OBSERVATION/SUBMISSION TO PLANNING APPLICATION

Case Reference: 324113

Re: Observation to the proposed development of open-cycle gas turbine (OCGT) and generator with ancillary equipment.

Location: Pollnagroagh and Rathmorrissy (Townlands), Athenry, Co. Galway

Purpose		PLANNING			
Title		SITE ACCESS SIGHTLINES			
Original Scale	Design/Drawn	Checked	Authorised		
SHOWN at A1	PS	ND	AJB		
Date	Date	Date	Date		
01.12.25	01.12.25	01.12.25	01.12.25		
Status	Drawing Number	Rev			
A2	PEK3-ATK-ZZ-01-DR-CE-901200	0

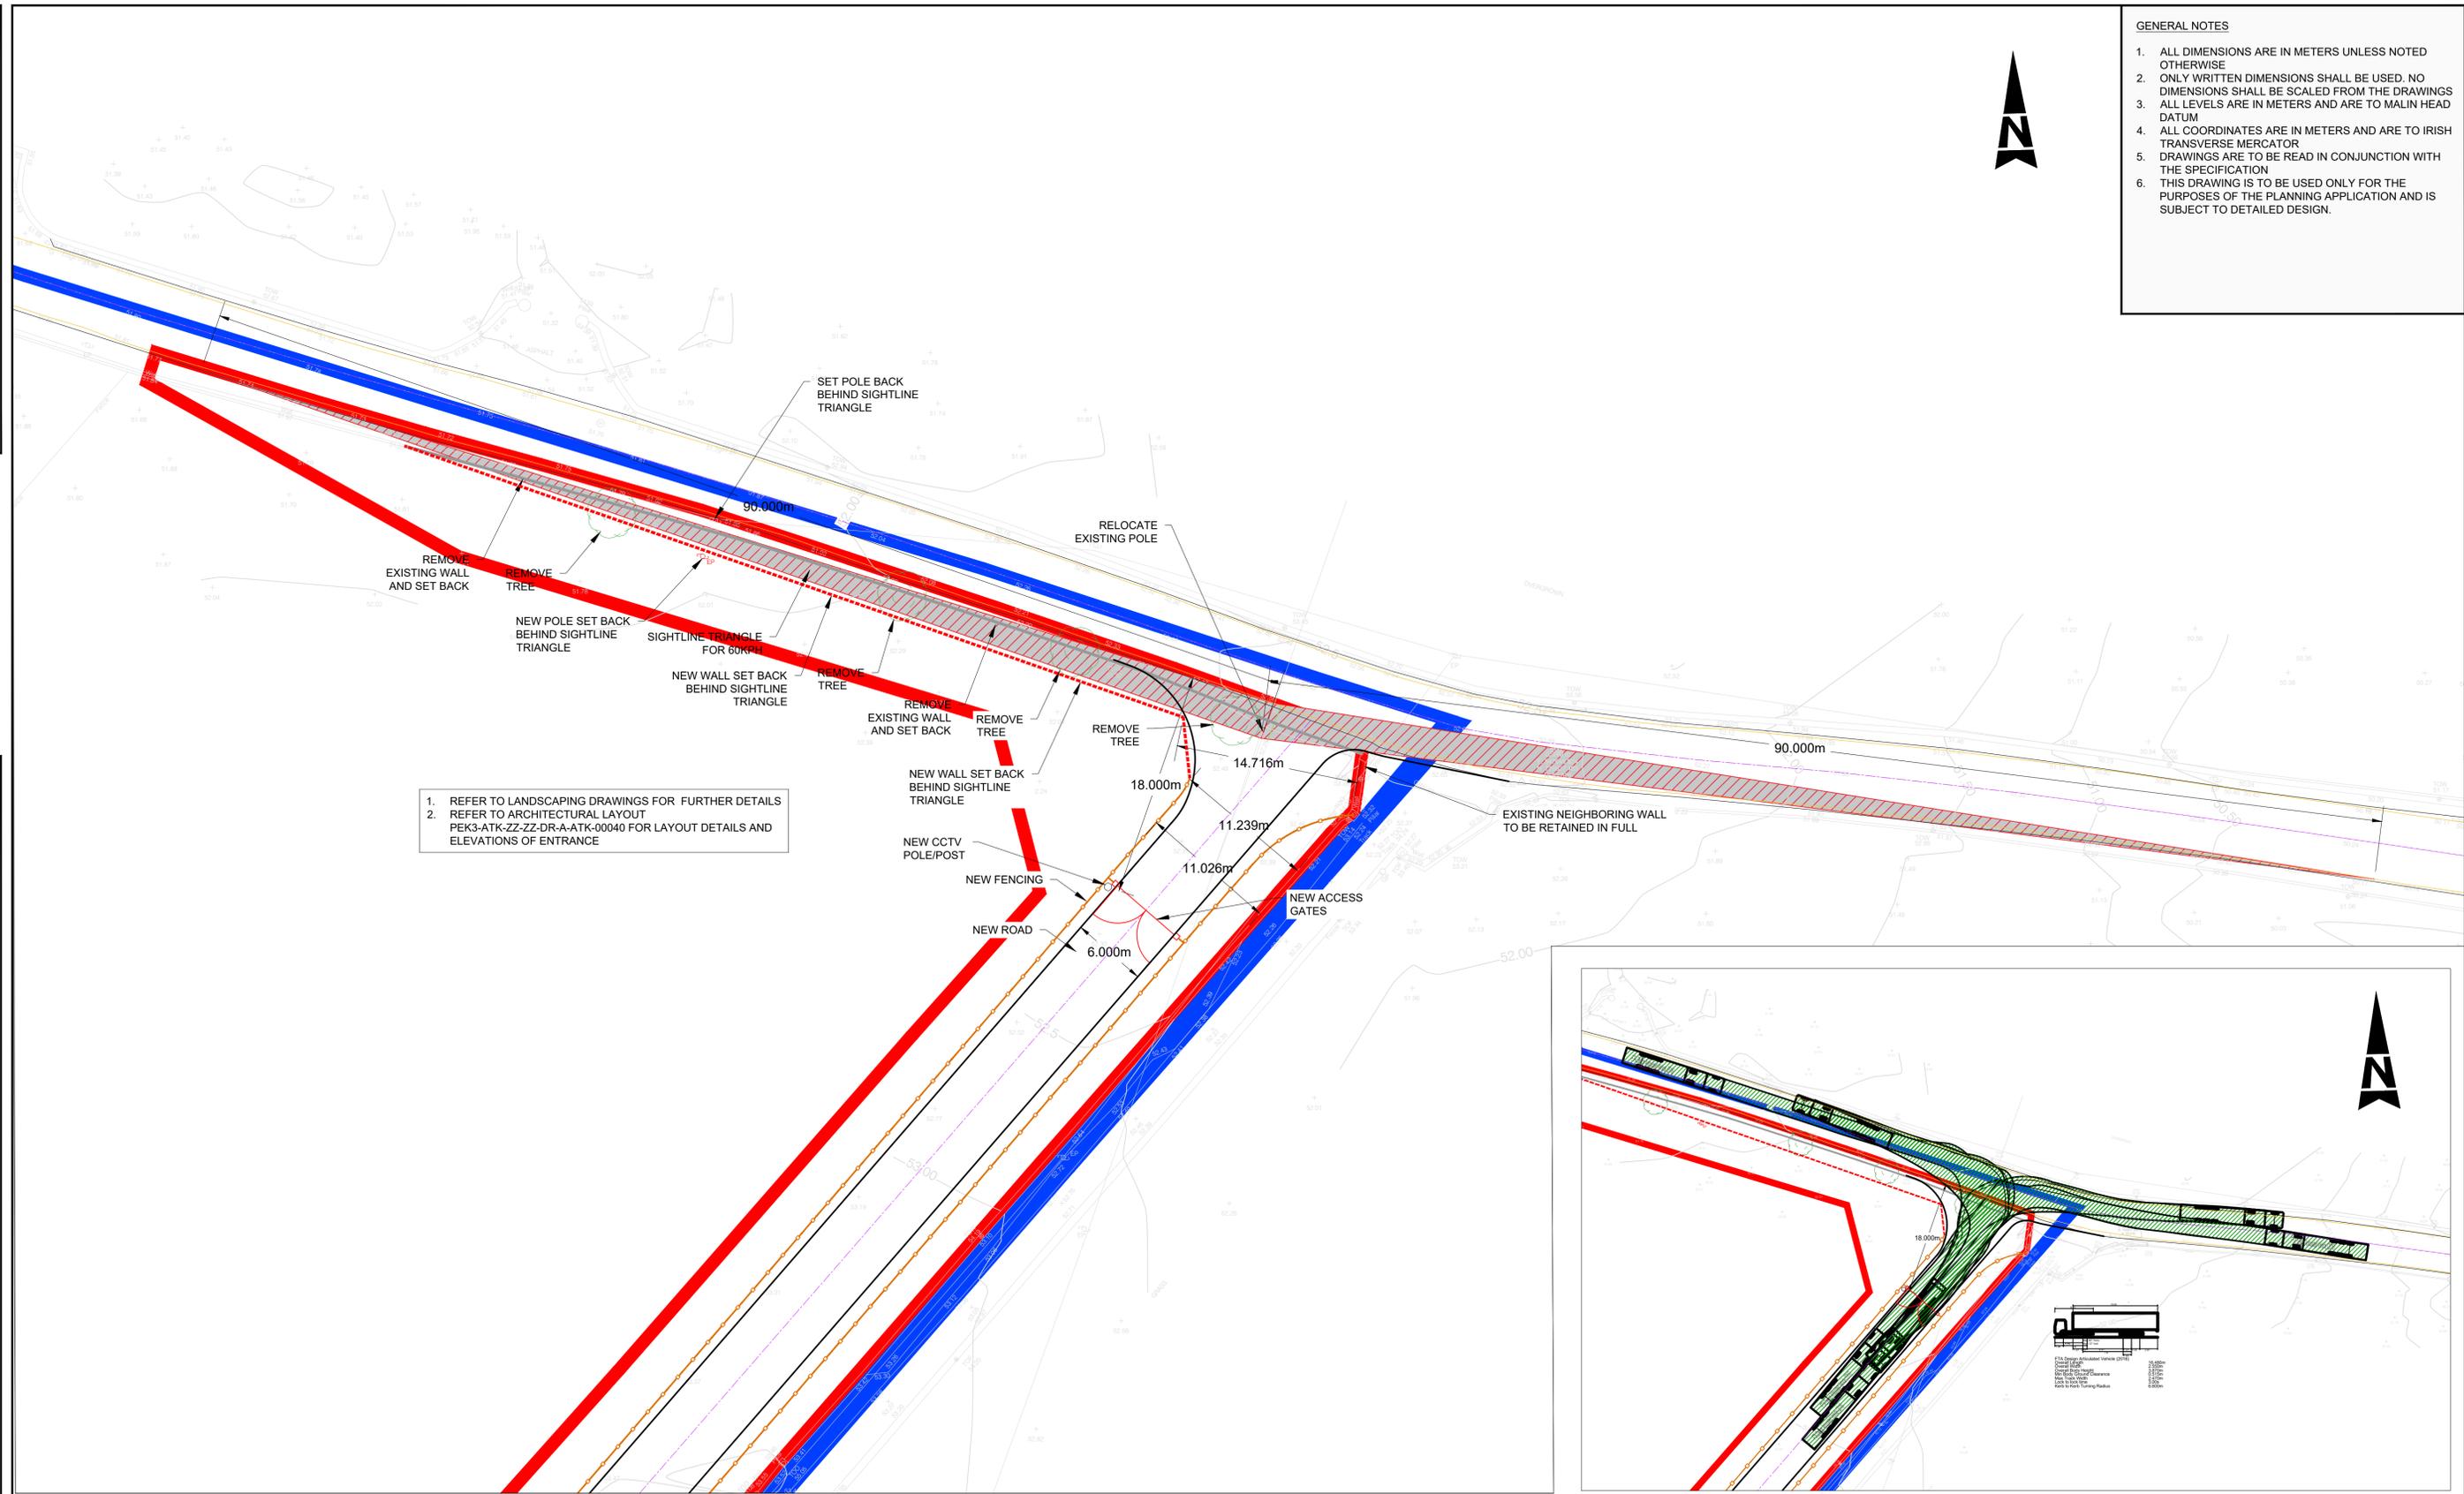
Positioning the site entrance at this location on the L3103 introduces extreme risk to road users. This treacherous section of the road is entirely devoid of a hard shoulder and is physically too narrow for two HGVs to pass one another safely. Furthermore, severely compromised sightlines caused by blind dips and sharp corners make this access point highly perilous. It is imperative that these severe, compounding traffic hazards are urgently mitigated before any development is permitted.
